## REFUSAL OF PLANNING PERMISSION

APPLICATION NO. 2018/1374

**Proposal** Erection of brick outbuilding to the rear of dwelling (retrospective)

**At** 21 Kings Court, Wombwell, Barnsley, S73 0FB

Revision :	
Scale :	1:50 @A3
Date :	Nov 18
Drawn by :	KL
Project :	Proposed Garden Room
Title :	Planning Drawing
Drg No :	GR/01
Rev :

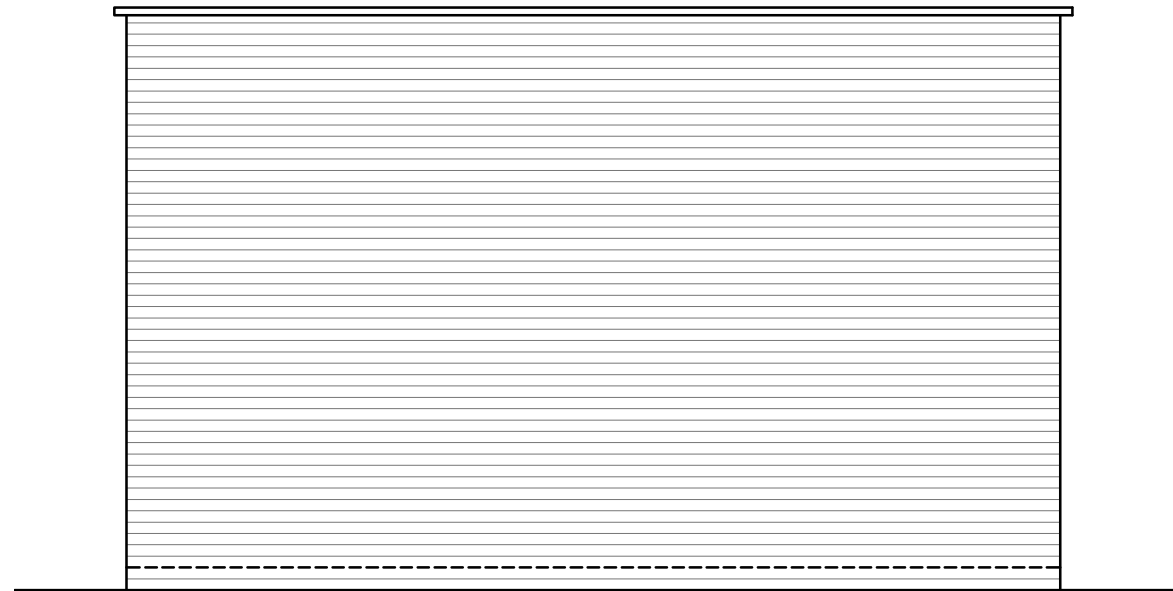
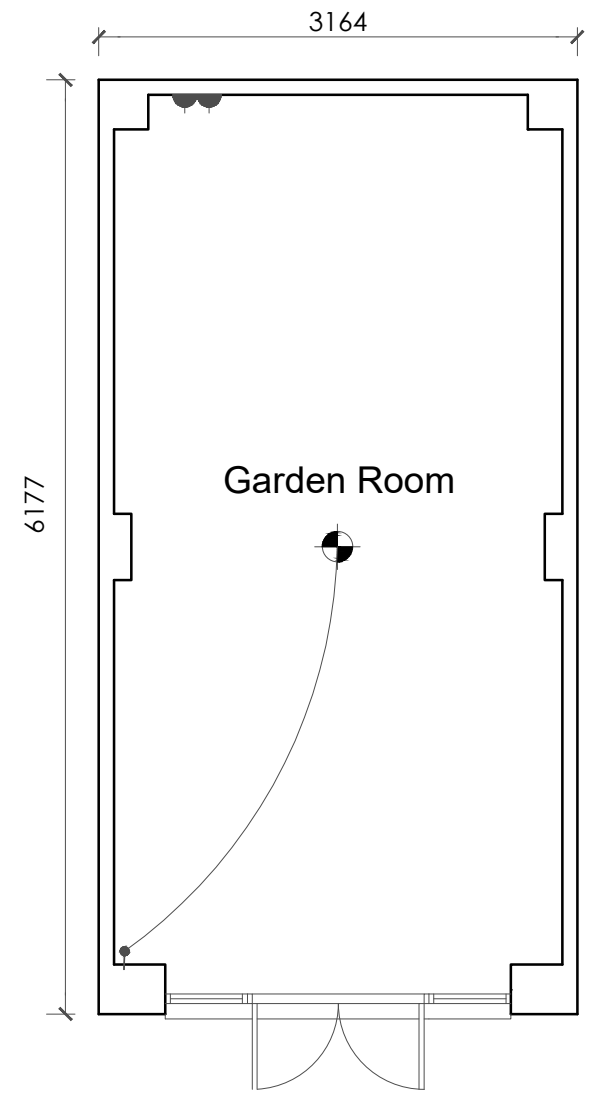
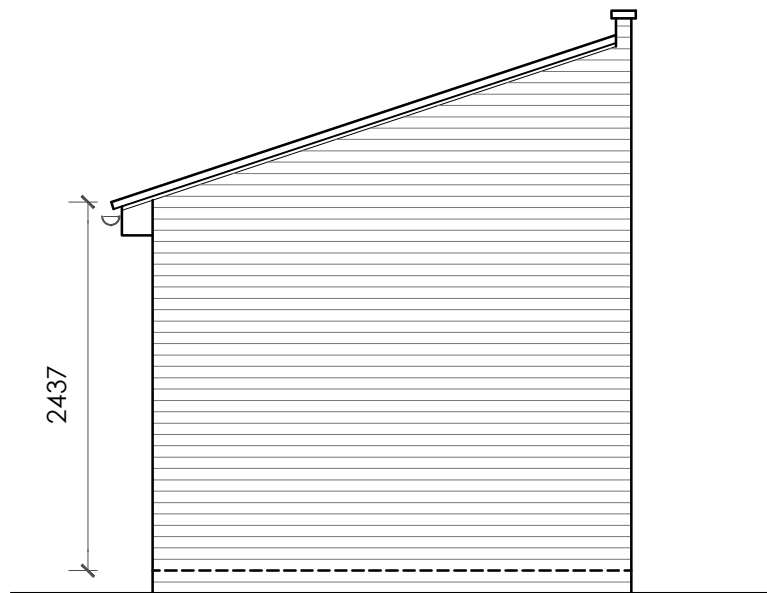
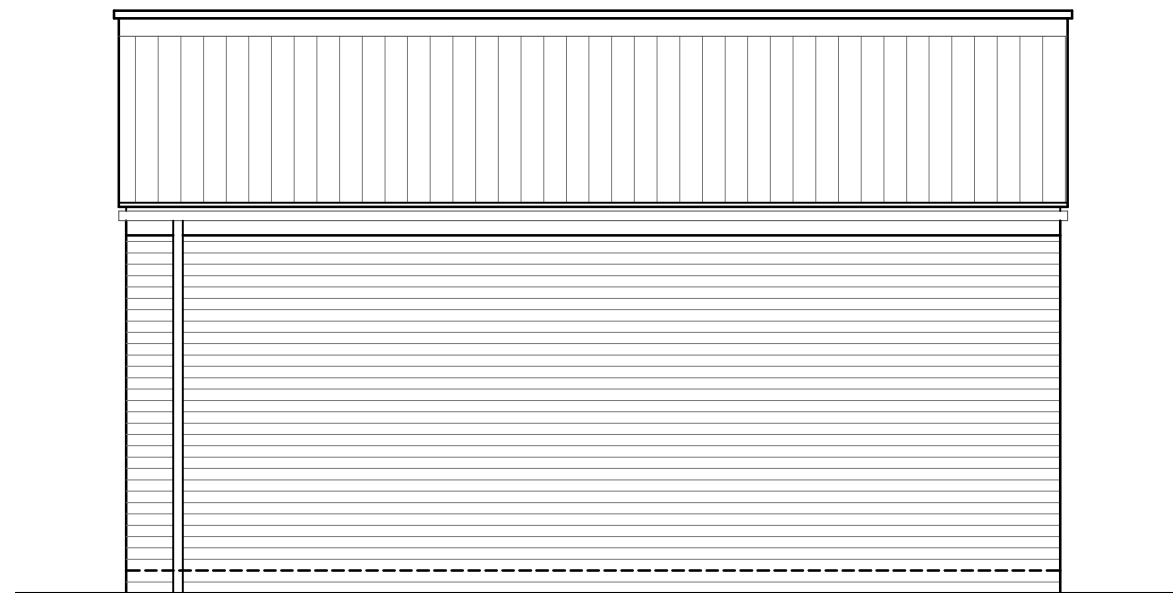
- 1 In the opinion of the Local Planning Authority the outbuilding is contrary to Policy D1: High Quality Design and Place Making of the local plan which states that 'development is expected to be of high quality design' and paragraph 130 of the NPPF which states that 'permission should be refused for development of poor design that fails to take the opportunities available for improving the character and quality of an area', in that its design (roof design and large side gable wall) is architecturally inconsistent with the character of the property and as a consequence appears out of character to the host dwelling and the surrounding properties to the detriment of visual amenity.
